**Consultation Response from KC,  
Lead Local Flood Authority****2025/92737 rear of, 23 to 43, Moor Lane, Gomersal, Cleckheaton, BD19 4LF****Discharge of details reserved by conditions 10 (Phase II Intrusive Site Investigation Report), 11 (Remediation Strategy), 14(a) (coal mining activity), 16, 17, 18, 19, 20 (drainage), 21 (CEMP), 23 (estate roads), 24 (acoustic barrier) on previous permission 2023/92079 for outline application for erection of residential development of 10 dwellings, demolition of existing extension at 27 Moor Lane, widening of existing access and realignment of boundary walls.****Date Responded: 09/12/2025.****Responding Officer: Martin Stephenson****Responding Ref: 2****Previous response by the LLFA**

**Discharge of Drainage Conditions**

- No. 16 (Foul & Surface Water Drainage)
- No. 17 (Exceedance Flood Routing)

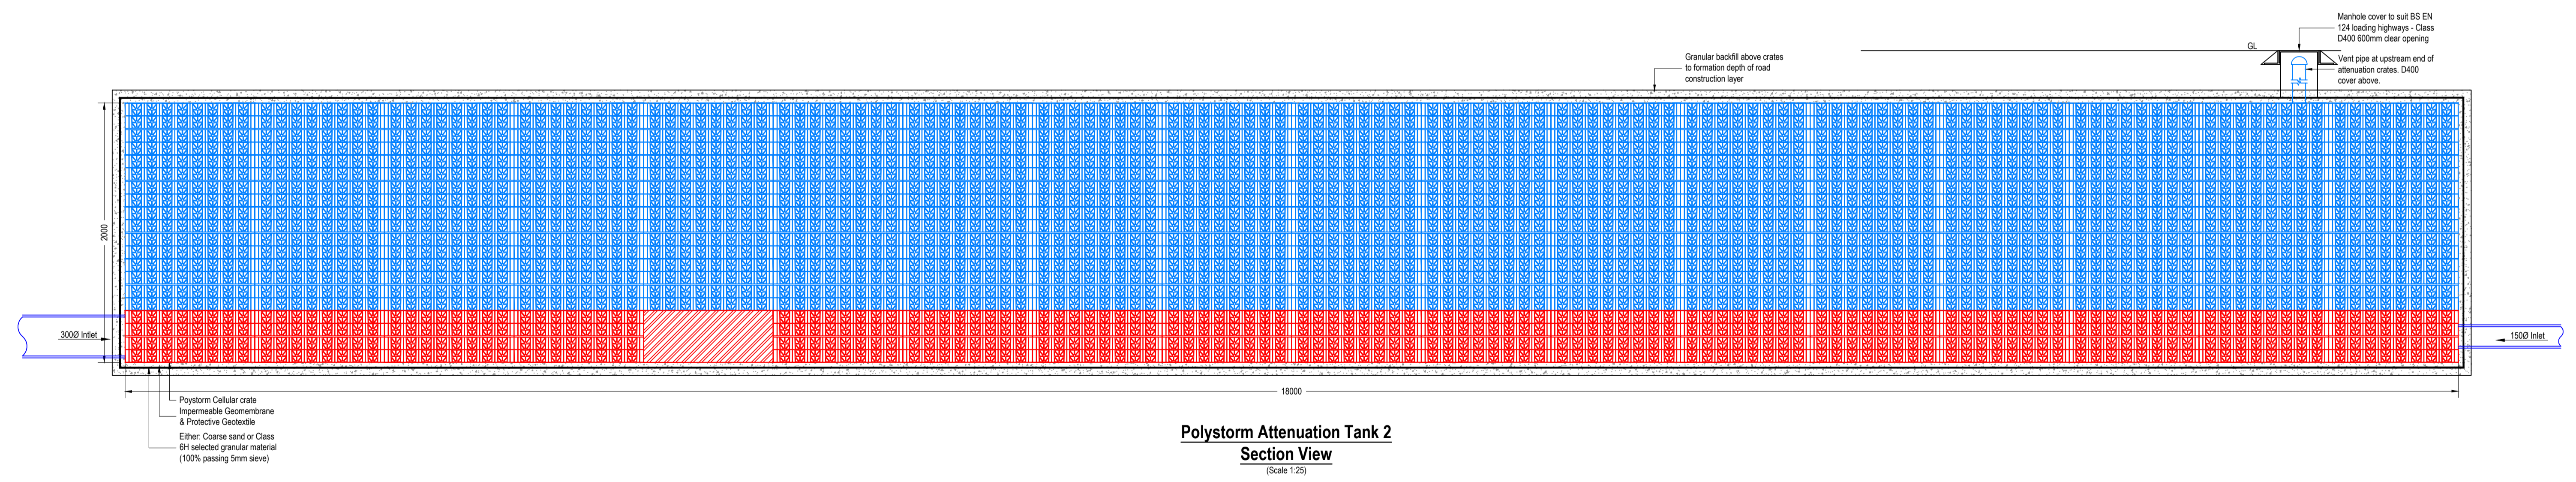
Attenuation Tank 2 Detail does not indicate a method of venting the top of the tank as it fills above the soffit levels of the inlet/outlet pipework. Please revise this drawing to show adequate ventilation and re-submit.

Drainage Layout

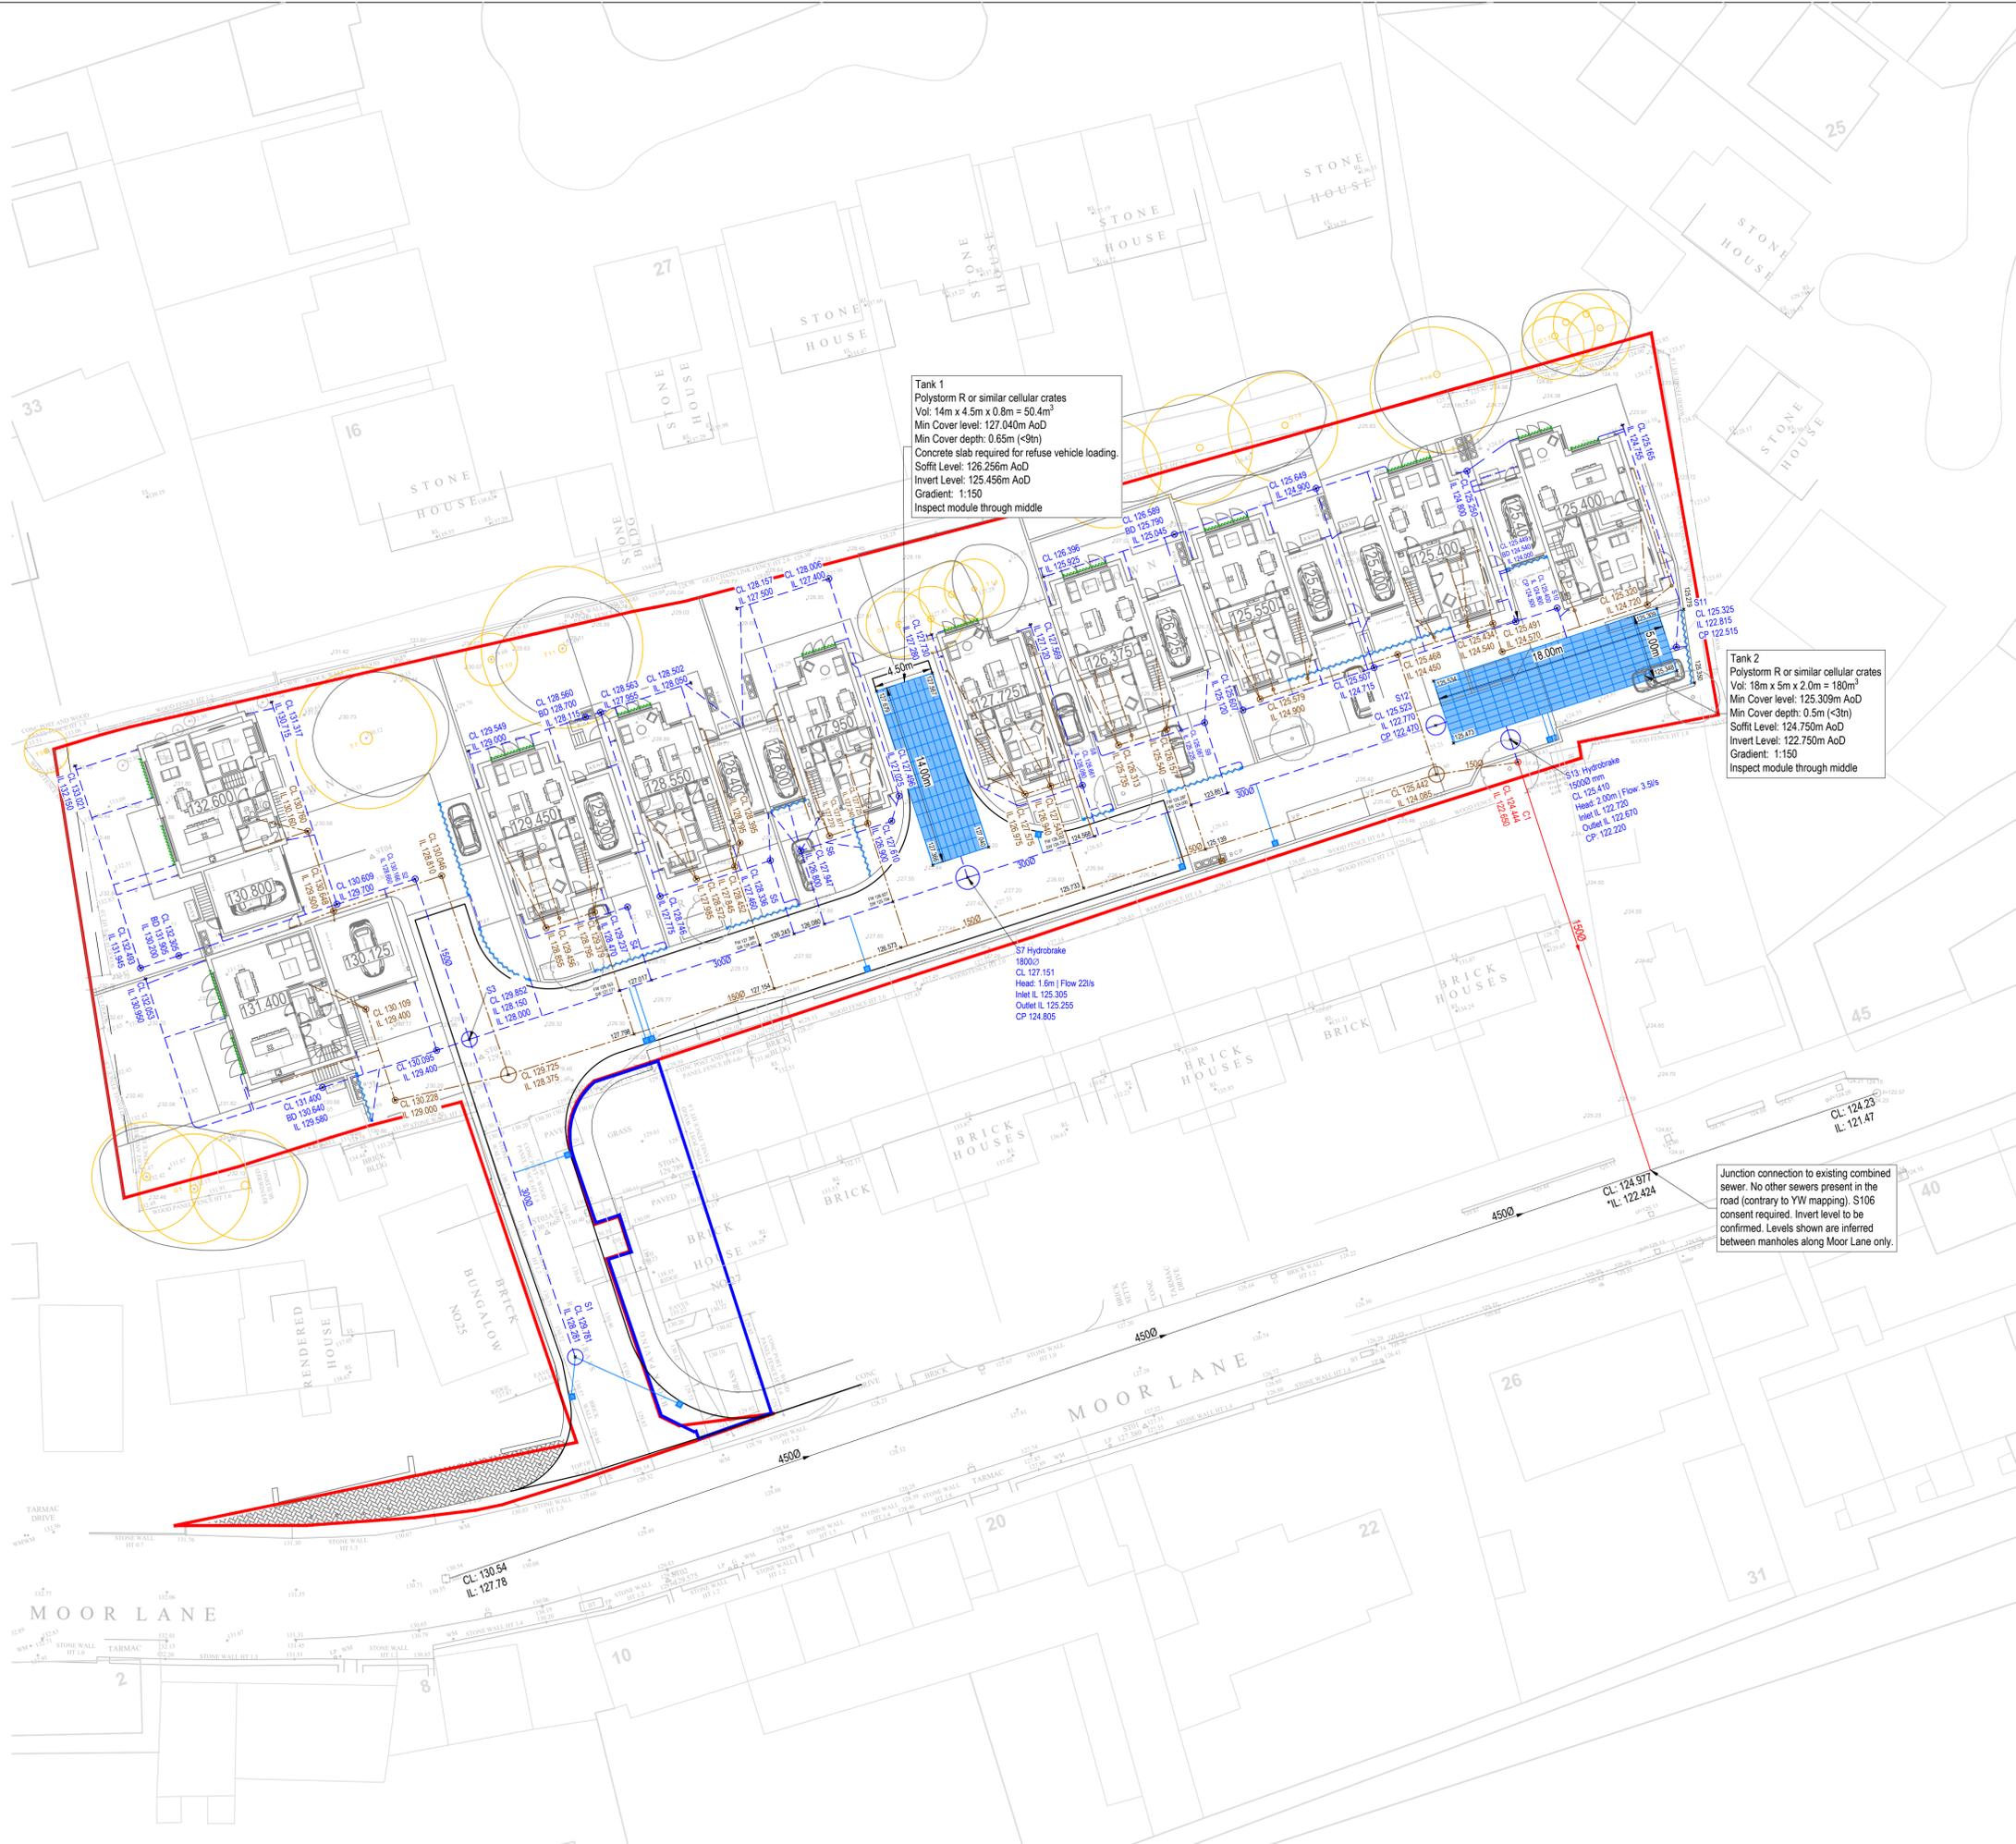
New information received after the LLFA's previous response dated 05/11/2025 indicates that there is a surface water sewer in Moor Lane and, as such, there should be separate foul and surface water drainage outfalls from the site through the 3<sup>rd</sup> party land belonging to No. 41 Moor Lane. Please revise the F&SW Drainage Plan to show the outfall from the flow control chamber connecting to the Yorkshire Water Surface Water sewer in Moor Lane and a separate foul outlet drain connecting to the Yorkshire Water Combined sewer in Moor Lane (both connections are subject to YW approvals and an agreement being in place to cross 3<sup>rd</sup> party land). Please revise this drawing and re-submit.

The Revision Box on Rev P02 of the F&SW Drainage Plan indicates that the drawing has not been checked or approved – has adequate Quality Assurance of the drawing been undertaken?
